DRIFTWOOD ESTATES FILING NO. 1

A SUBDIVISION IN THE NORTHEAST QUARTER OF THE NORTHEAST QUARTER OF SECTION 33, TOWNSHIP 11 SOUTH, RANGE 67 WEST OF THE 6TH P.M. EL PASO COUNTY, COLORADO

FILE NO. MS-23-009
OCTOBER 16, 2023
PROJECT 23054
SHEET 1 OF 1

# DRIFTWOOD ESTATES FILING NO. 1

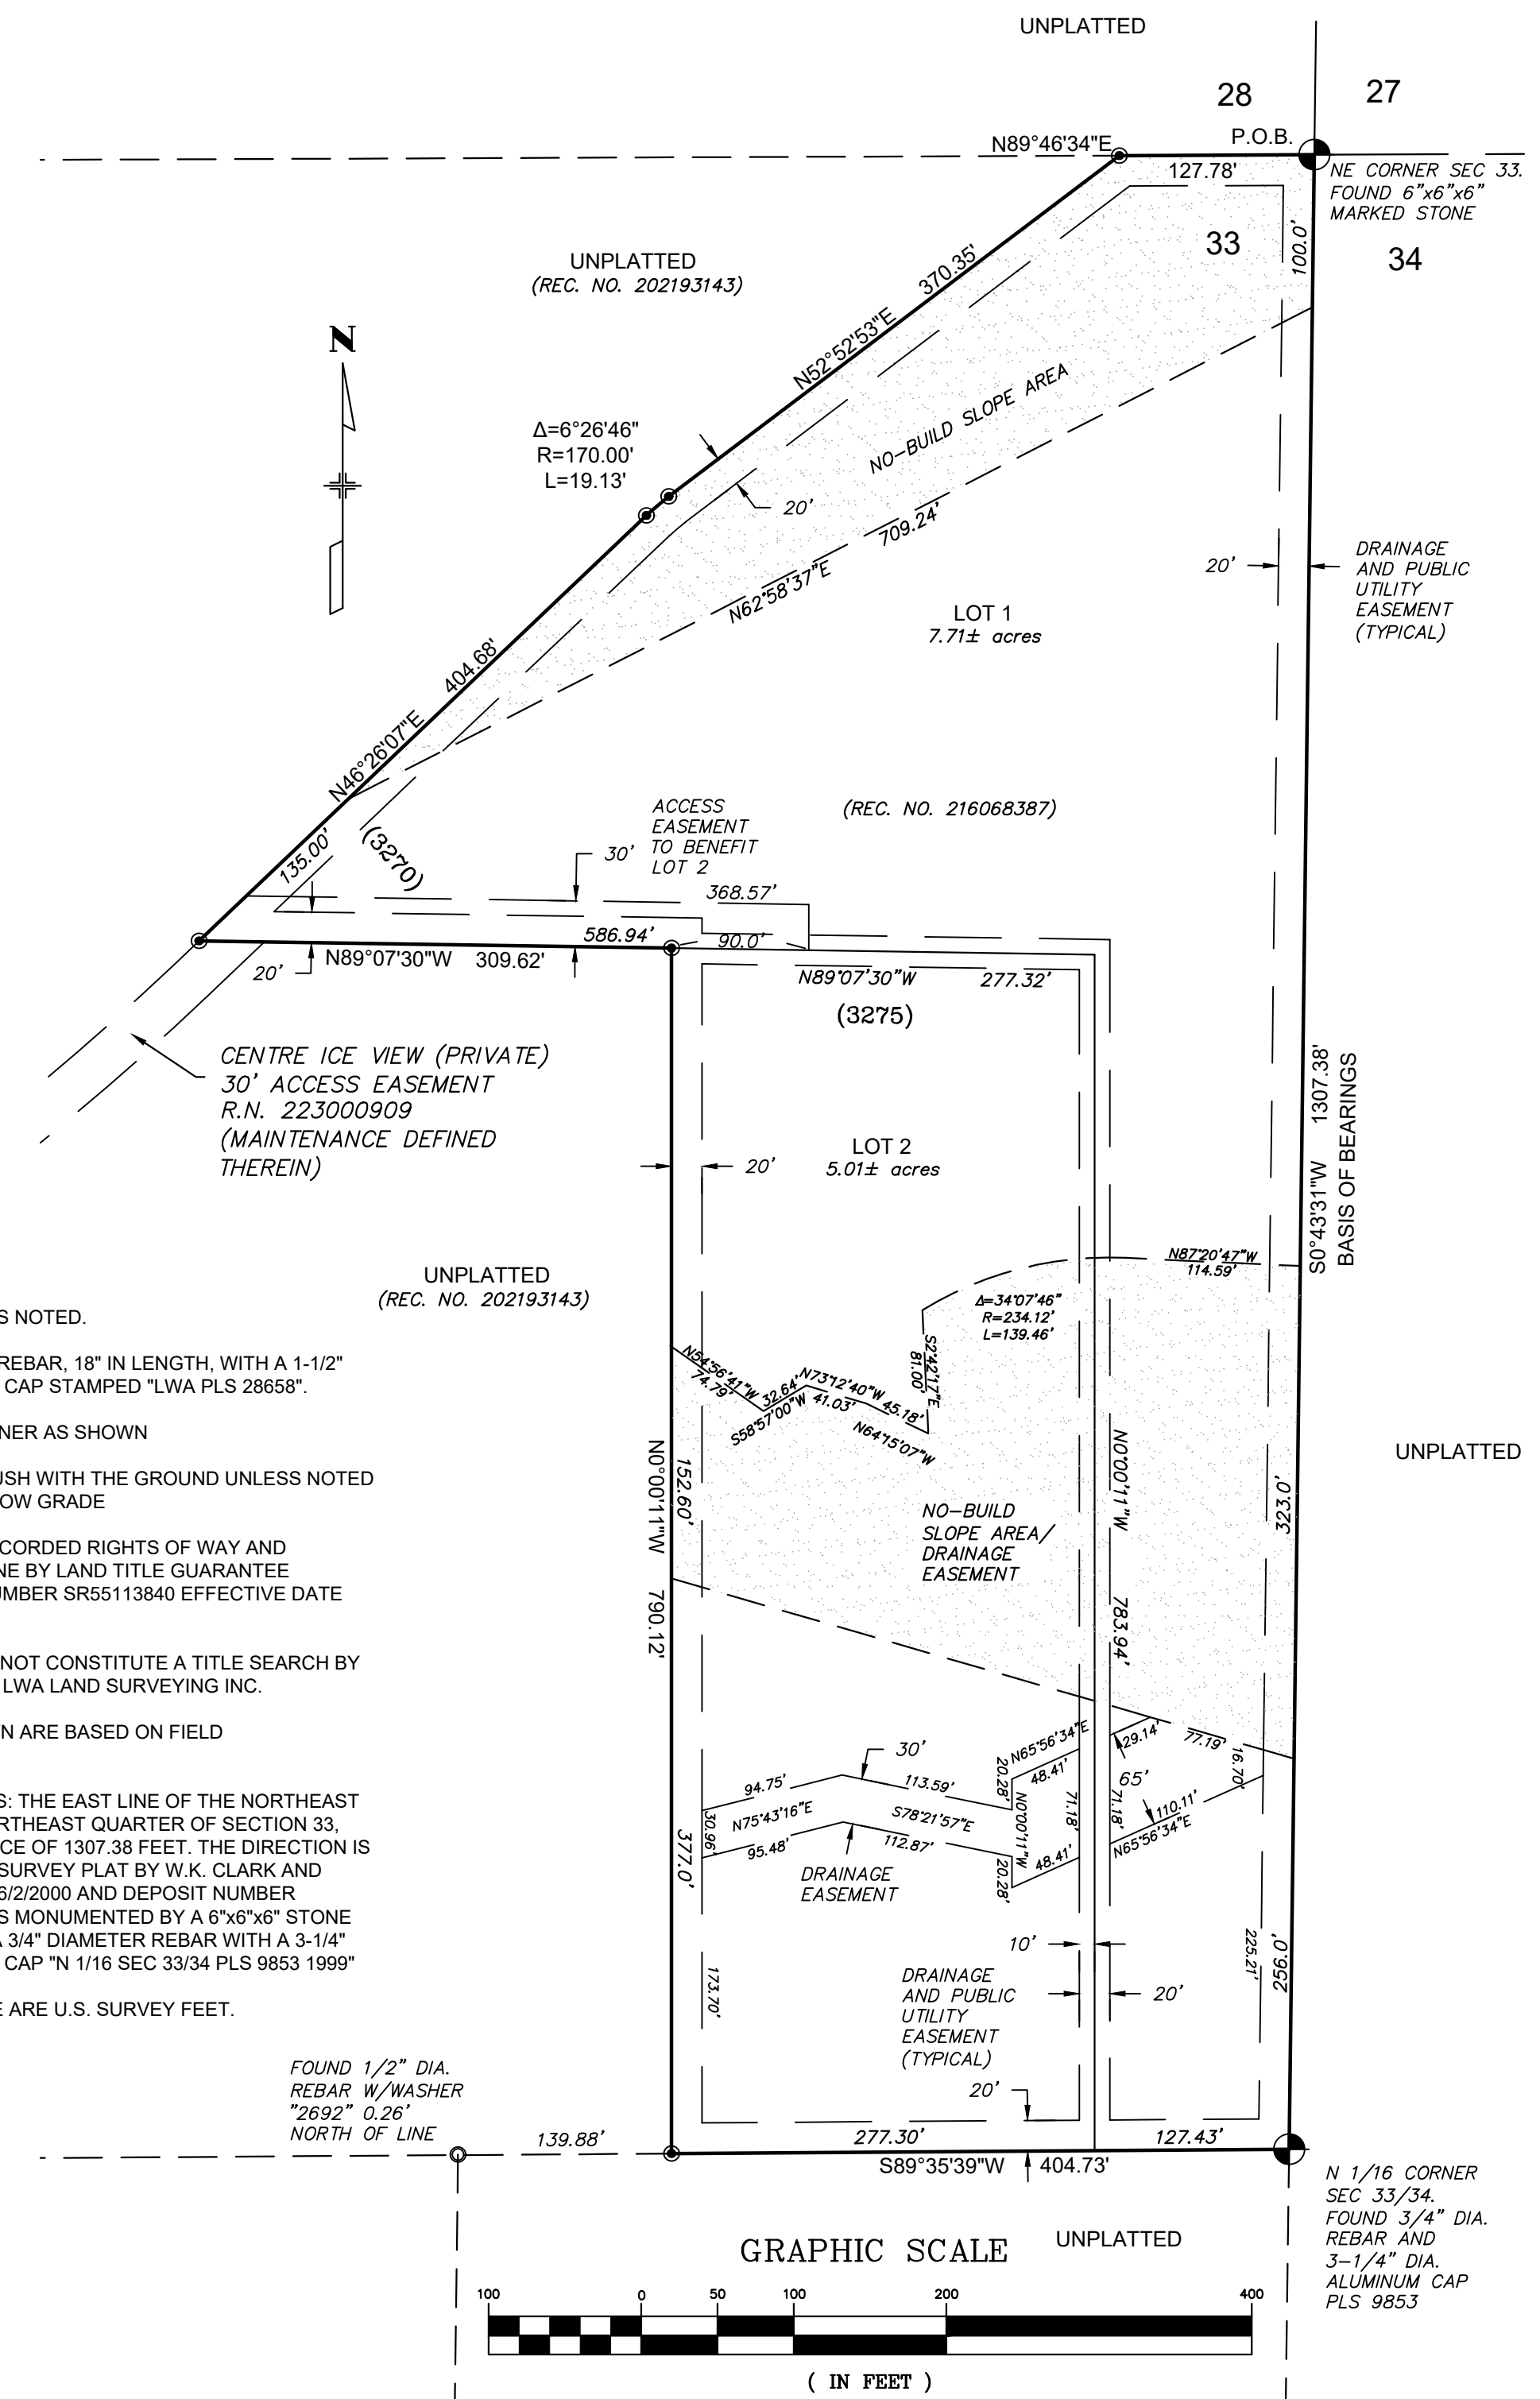
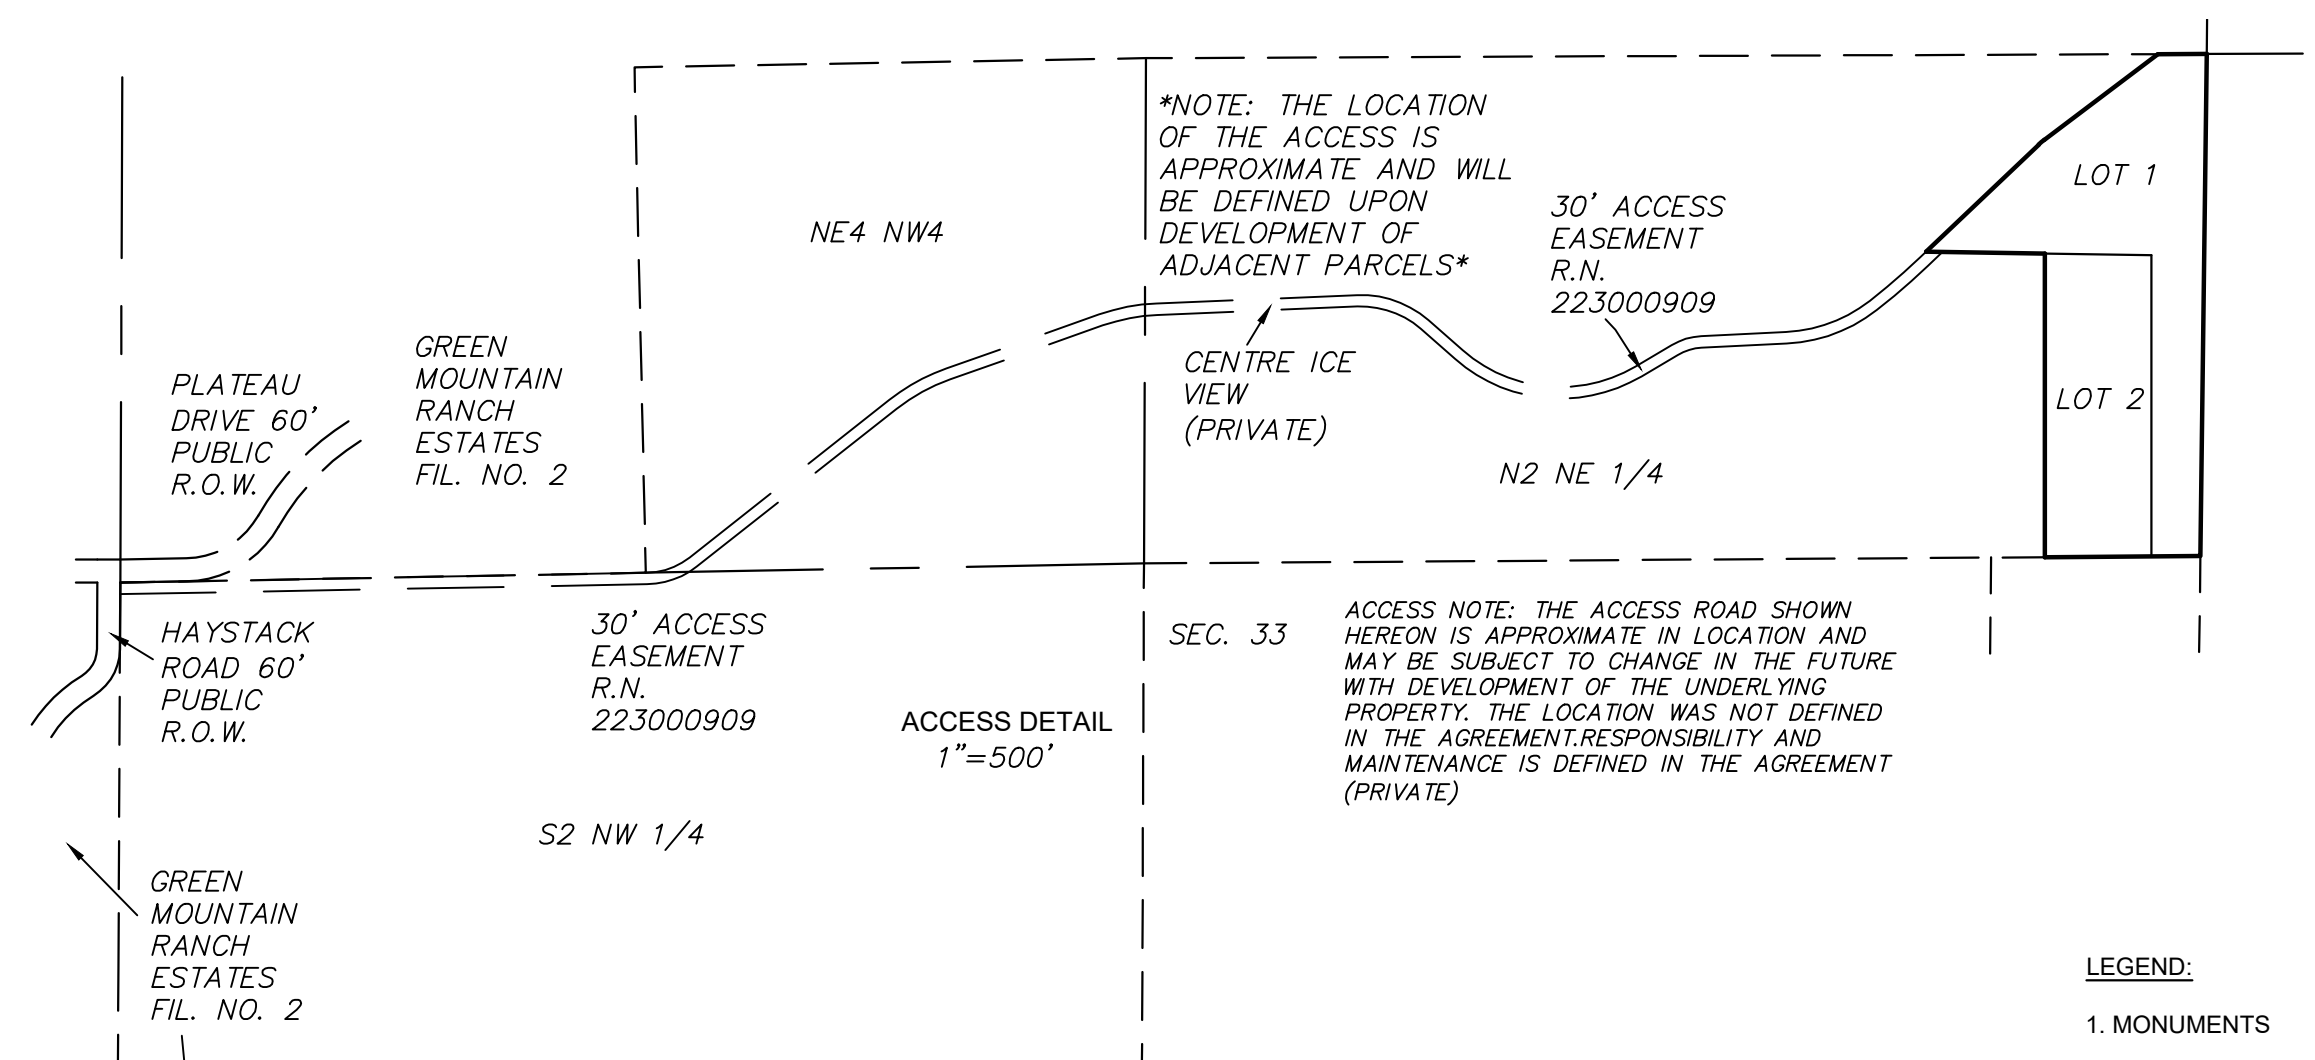
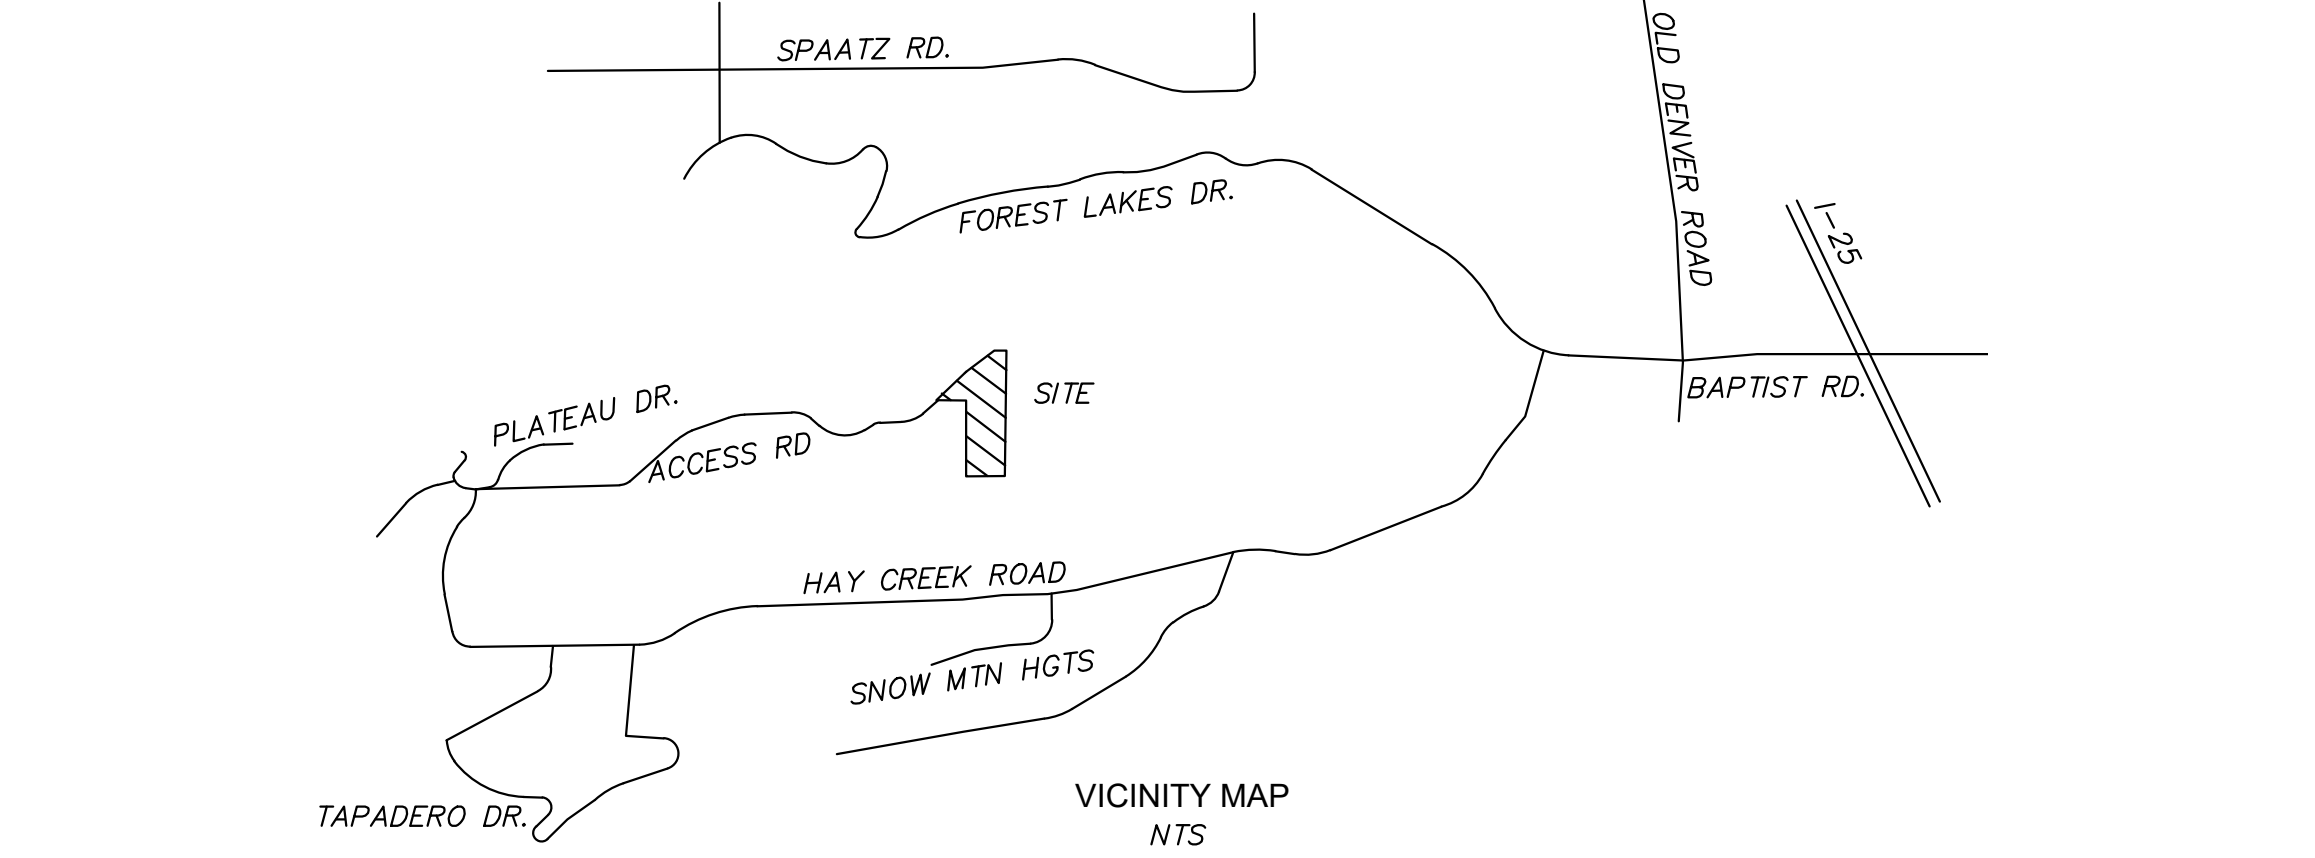
8.4.3 Division of Land Standards
(B)(1) Minimum Frontage for Division of Land. A division of land shall have a minimum of 60 feet frontage on a public road.
(B)(2)(e) Minimum Frontage. Lots shall have a minimum of 30 feet of frontage on and have access from a public road, except where private roads are approved by the BoCC pursuant to waiver granted under Section 8.4.4 (E).
A waiver will be required due to road access. Please review and address LDC Sec 7.3.3 Criteria for Approval of Waivers in the LOI.

The soils and geology report label this area as no build. Please clarify where the no build areas are.

The soils and geology report label this area as no build. Please clarify where the no build areas are.

Please add: Name, address and telephone number of the owner of record in the lower right hand corner.
